From: [REDACTED]
Subject: SizewellC
Noise pollution from proposed Sizewell rail link
Date: 06 September 2021 15:54:44
Attachments: [chart.png](#)
[Screenshot 2021-09-04 at 00.06.56.png](#)

I am writing with my concerns specifically relating to noise, air and vibration pollution along the route of the proposed Green rail route (GRR) . I am a resident who will be adversely affected by the construction of the GRR and the future running of it . I participated in the hearing ISH8 but feel there was insufficient, to convey the points I made and to be fully understood by the panel. I felt that the responses from the applicant's team were incomplete and dismissive.

DRAWING TITLE:  
**MAIN DEVELOPMENT SITE  
 TEMPORARY CONSTRUCTION AREA  
 RAIL WORKS  
 PROPOSED GENERAL ARRANGEMENT  
 SHEET 1 OF 4**

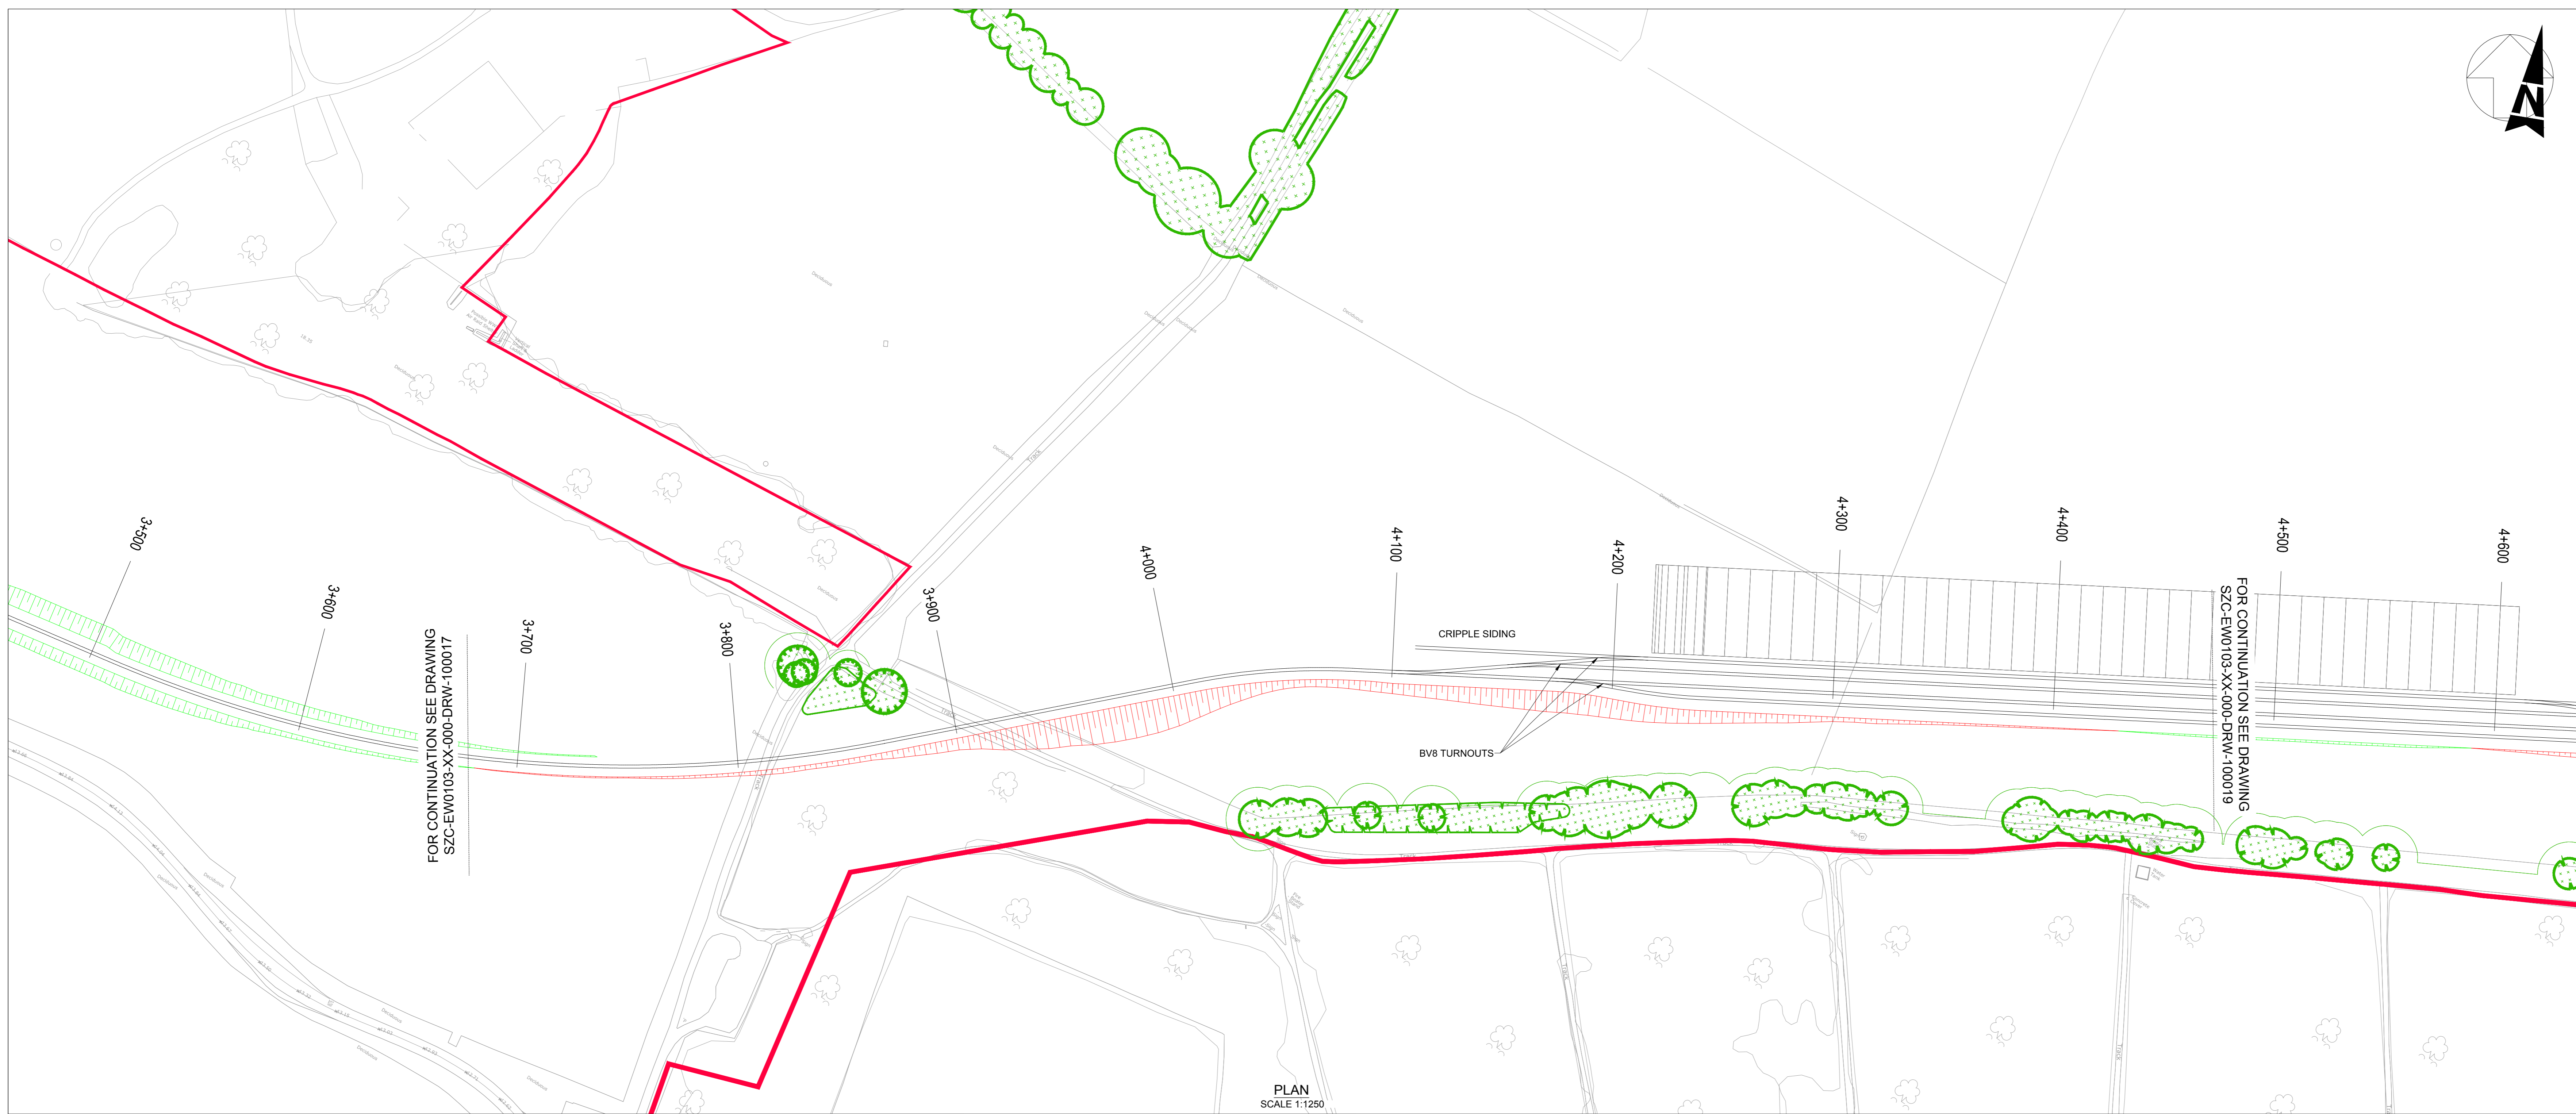
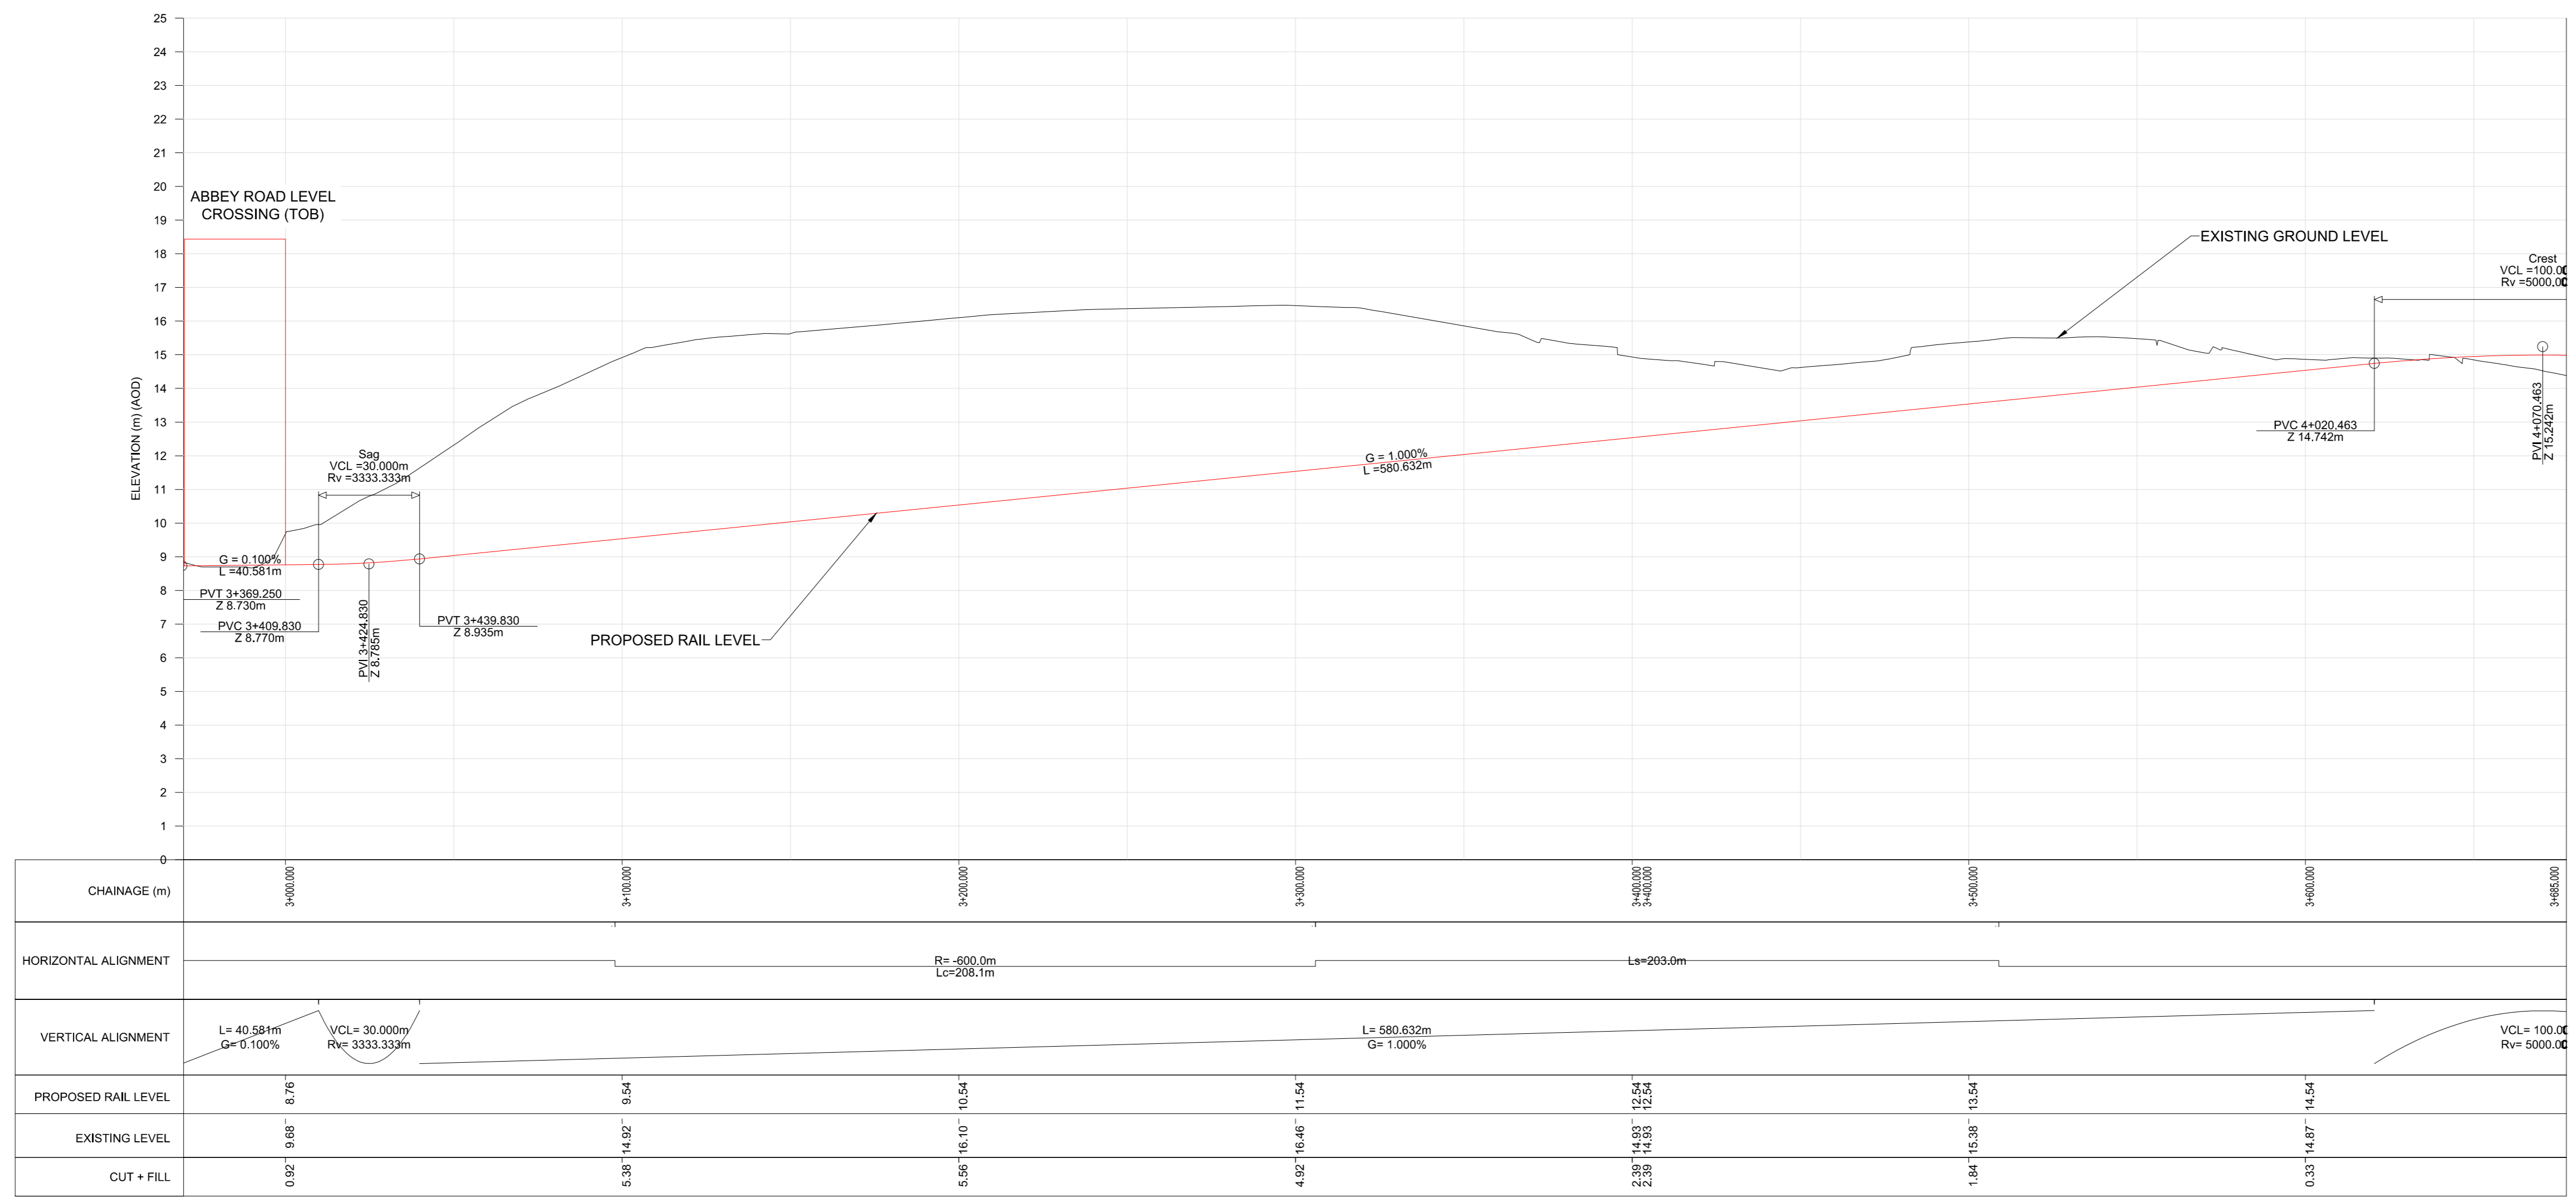
Secondly I would like to cover the topography . The first section of the GRR from the Leiston branch line to the Abbey road crossing, follows a channel in the land, accelerating air mass as it is funnelled through from the entry point between the north side of Leiston and Buckles Wood down towards Abbey road . When the cut is made on the next section from the eastern side of Abbey road to the Development site, this effect will more than likely worsen . So now we are building up a unique set of parameters; predominant wind direction, the funnelling effect of topography

My question to the applicant is; has full consideration been taken into account with the software used SoundPlan TM in respect of wind speed and direction and the effects of Snell's law of refraction?

I believe it doesn't and the modelling produced using ISO9613-2 implemented in the software as Mr Brownstone stated, uses an equal wind speed downwind in all directions . This isn't sufficient for the unique set of parameters presented by the GRR and the modelling is better suited to more urbanised built up area's similar to the Leiston branch line as it enters into the town .

I would suggest that the use of the Nord 2000 module within SoundPlan a better option as it deals with rural areas more accurately and wind speed and direction can be input. The question of whether it too would be able to accurately model the the exact parameters needed could produce a lively debate . So with this in question the need I believe for Accoustic fencing is paramount at the very least along the first section of the GRR and where suitable along the branch line and beyond . Mr Rhodes stated that Network rail would not allow acoustic fencing on their land however the GRR will be free of that restriction and it is crucial to minimise the negative impact caused by the rail noise . I also came across a few anomalies with the modelling given by the applicant which I would like to further

In summary it is my view that although a degree of modelling has been undertaken its suitability to be tested with real world conditions may be questionable . More acoustic surveys and modelling needs to be done and the use of Acoustic fencing needs to be included to absolutely minimise any detrimental impacts from noise pollution. Thank you for considering this submission.
